RE: 780 Wallgrove Road, Horsley Park SSD-9601 Modification – Response to Submission - Transport Statement

Reference has been made to the Fairfield City Council's (Council) response sent on 02 May 2022 in relation to Modification (MOD 1) for SSD-9601 at 780 Wallgrove Road, Horsley Park (the Site). In this regard, Brickworks Land & Development (Brickworks) have commissioned Ason Group to prepare a response to the Council comments. Details of our assessment are as follows.

Status	FOR REVIEW NOT TO BE USED FOR CONSTRUCTION	A1
Drawing No.	DAC031	Issue
Project No.	18-577	C

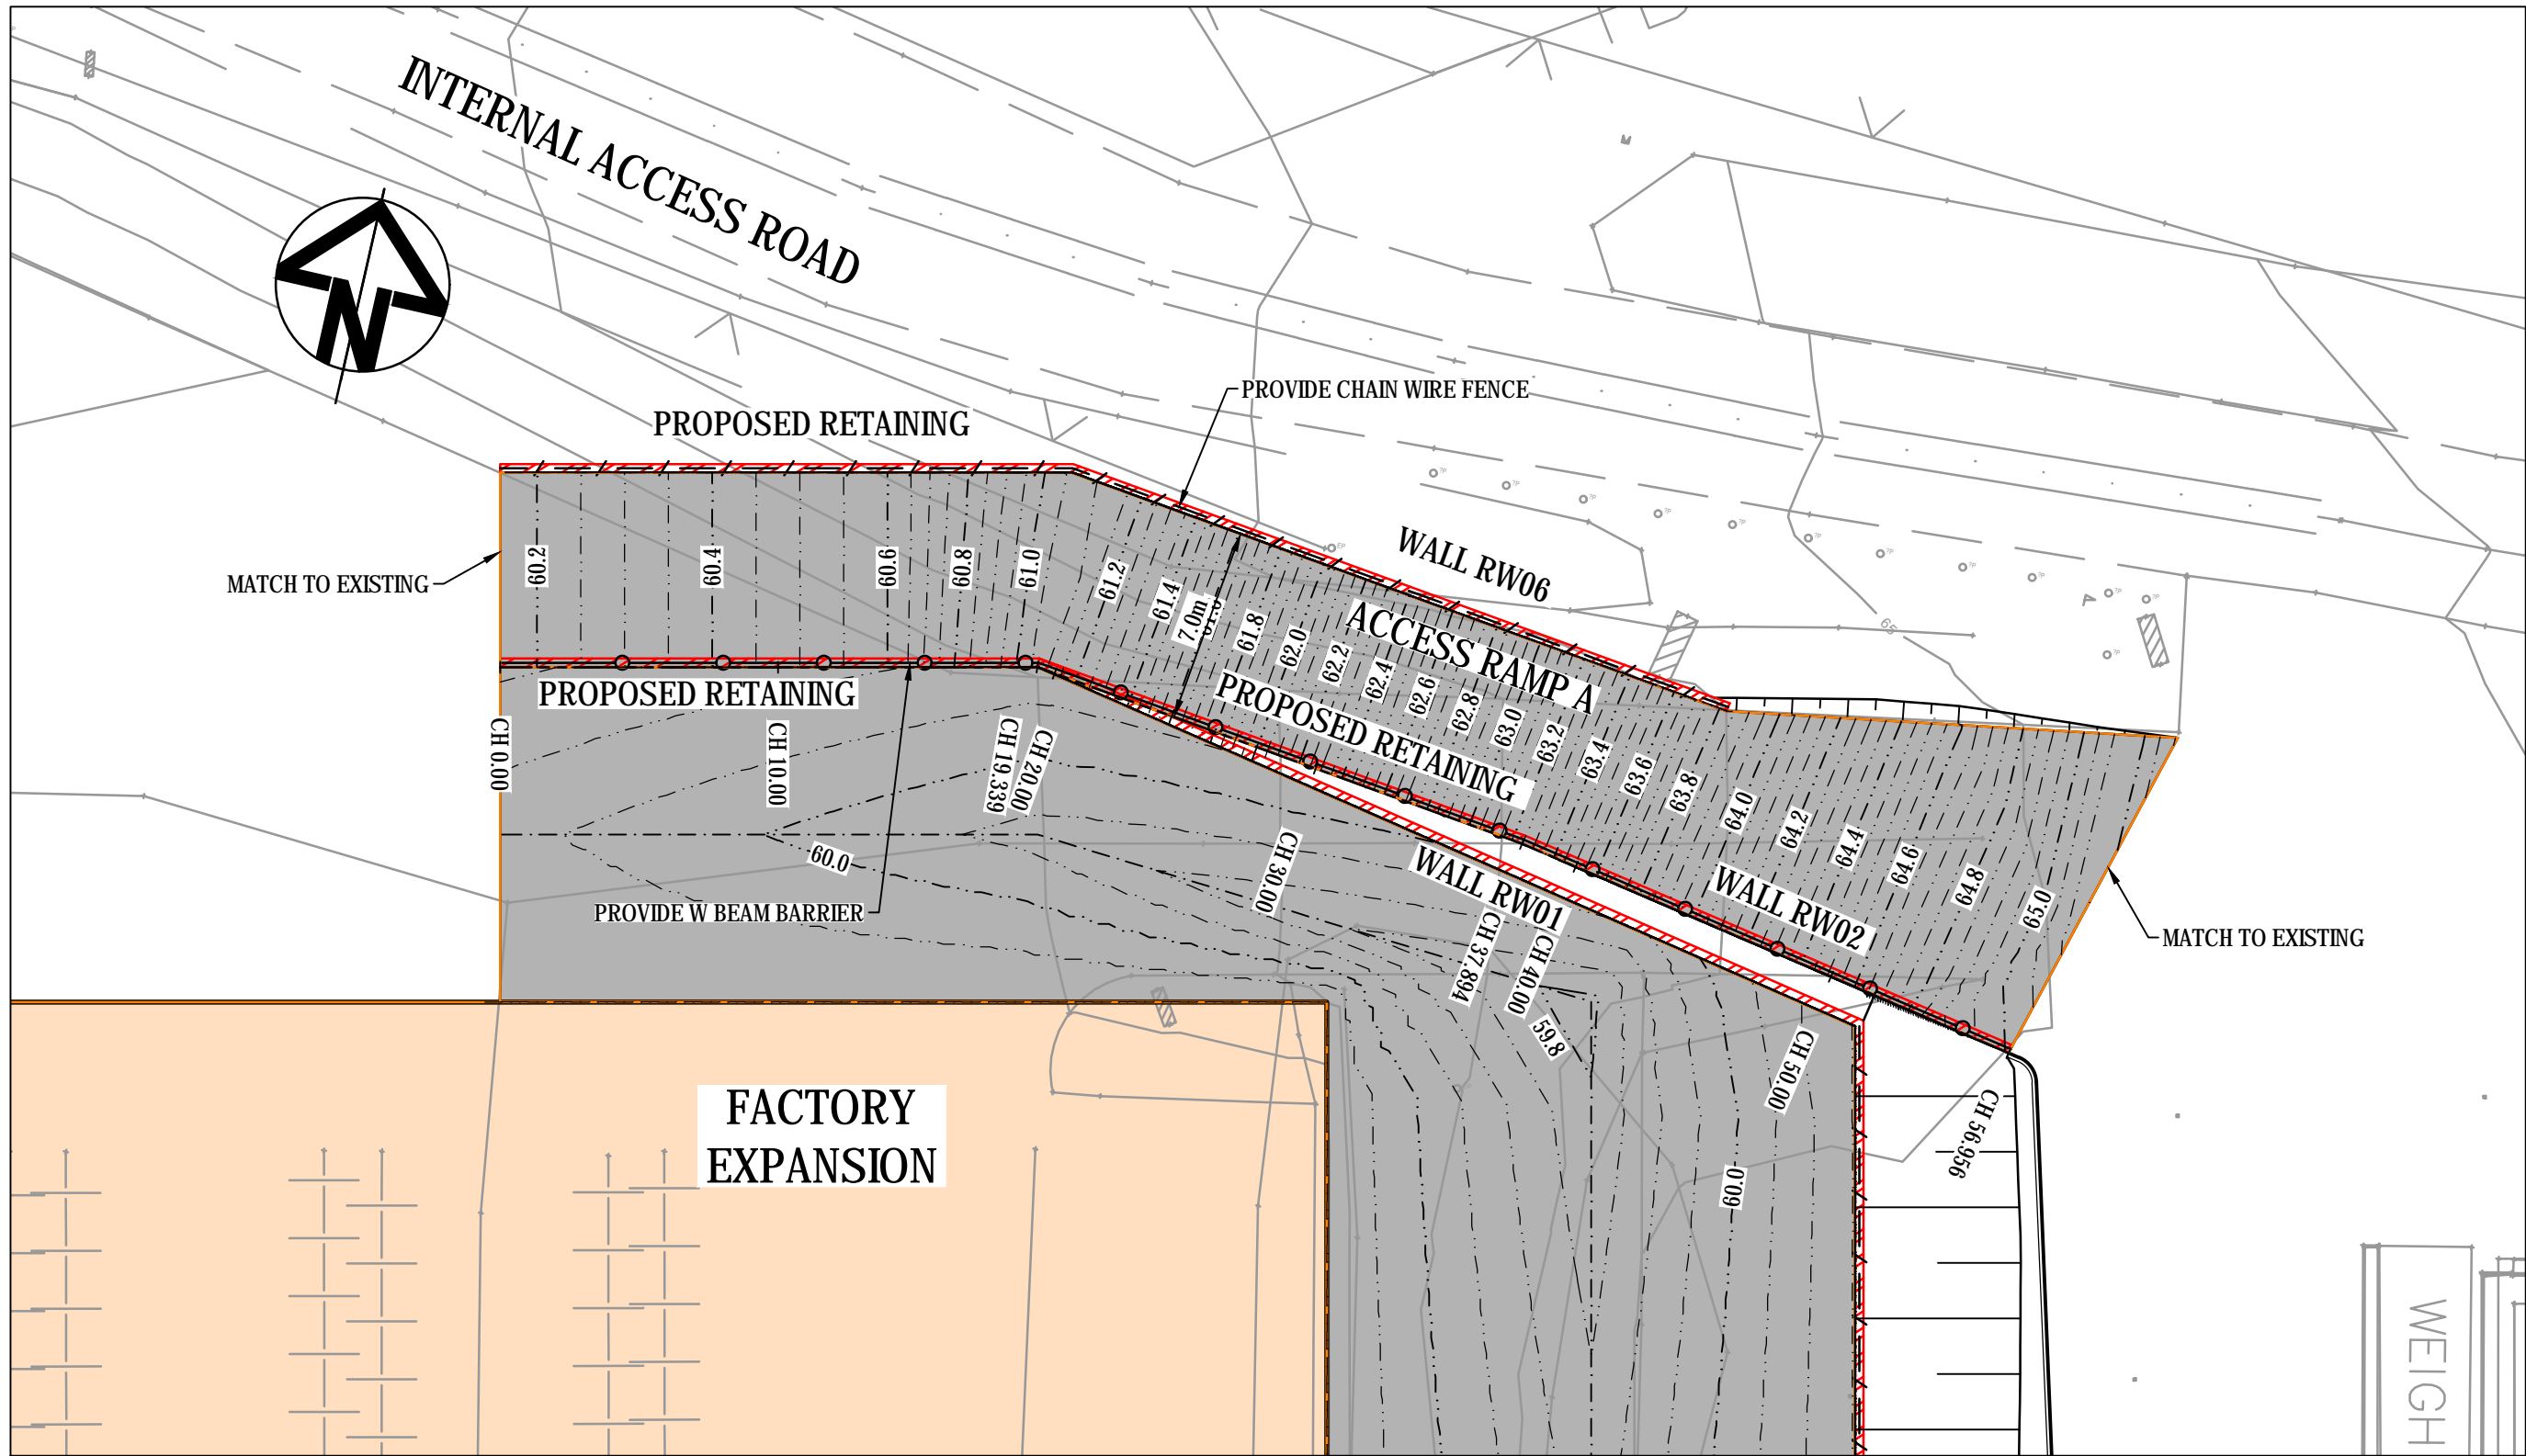
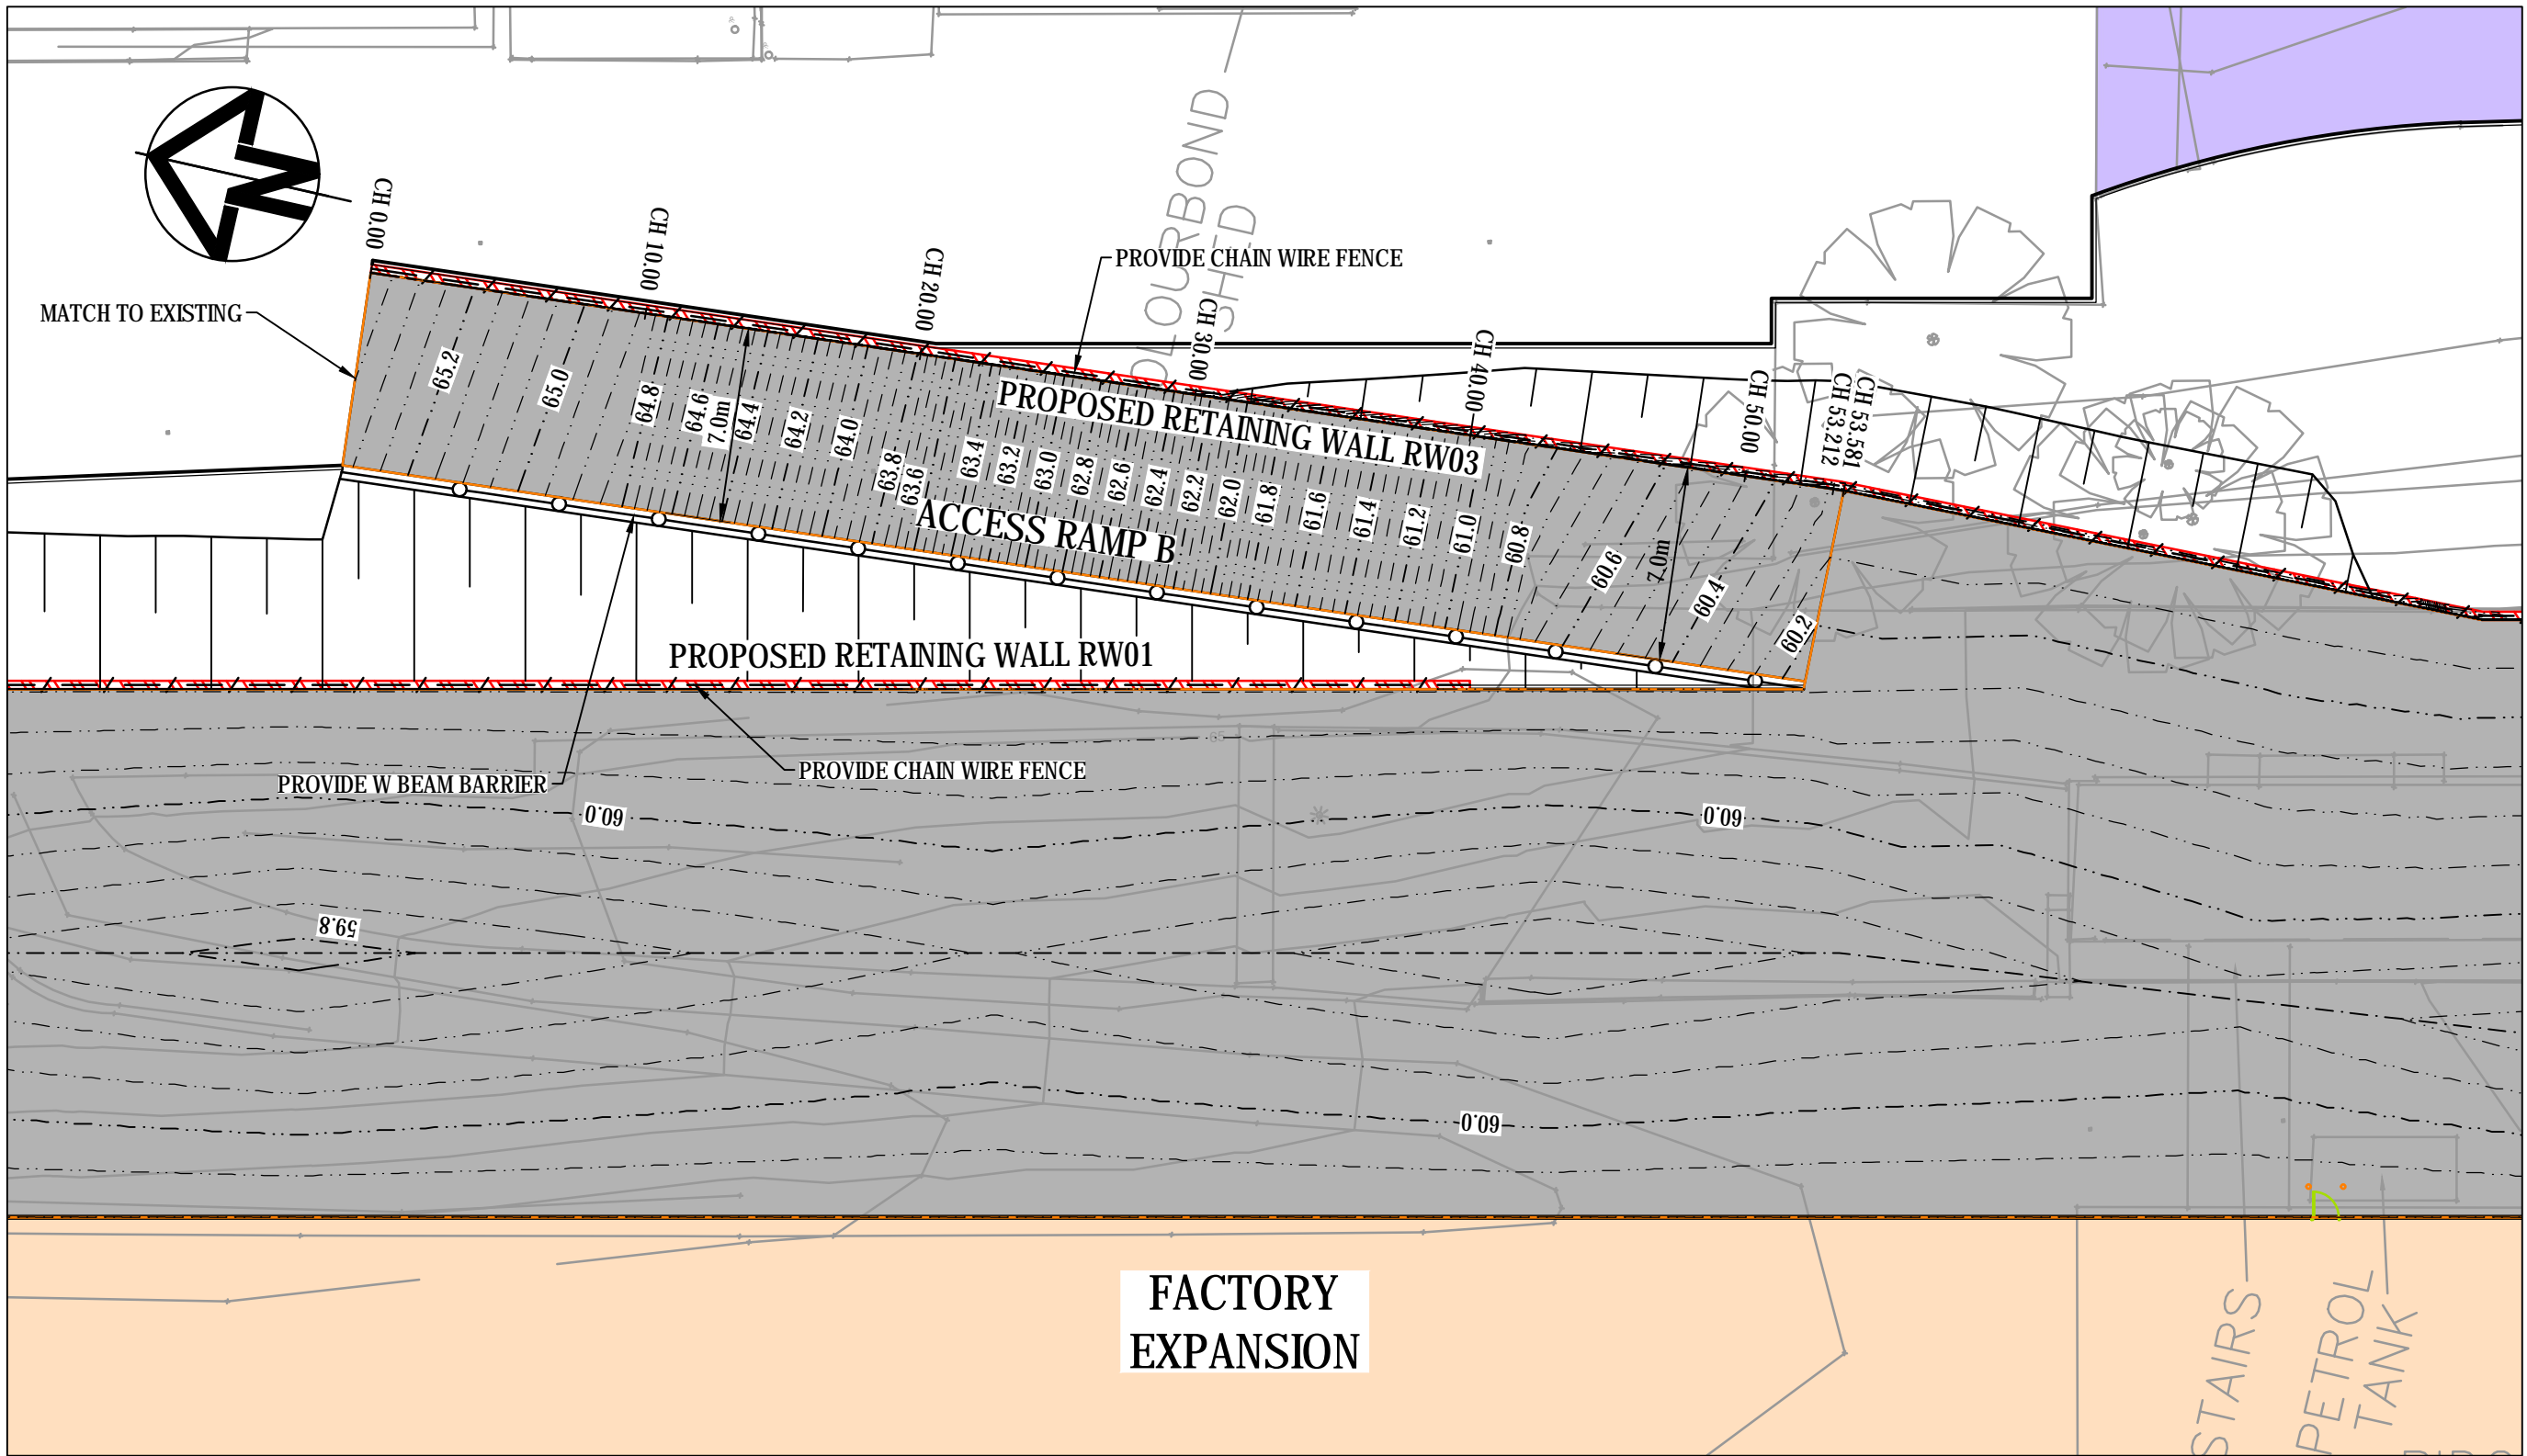
“Australian Standards (AS 2890.2:2018) does not specify a requirement for the maximum permissible allowable ramp grade for 26m B-Double vehicle. The applicant shall carry out investigation and submit additional information to Council for assessment regarding this matter;”

AS2890.2:2018, Table 3.2 stipulates the following regarding maximum grade of 26.0m B-Double vehicles.

As seen above, the maximum allowable ramp grade for a B-double vehicle is 1:8.3 (12%) and the maximum rate of change is 1:15 (6.25%) in 10m of travel. The proposed driveway has been designed in accordance with the above.
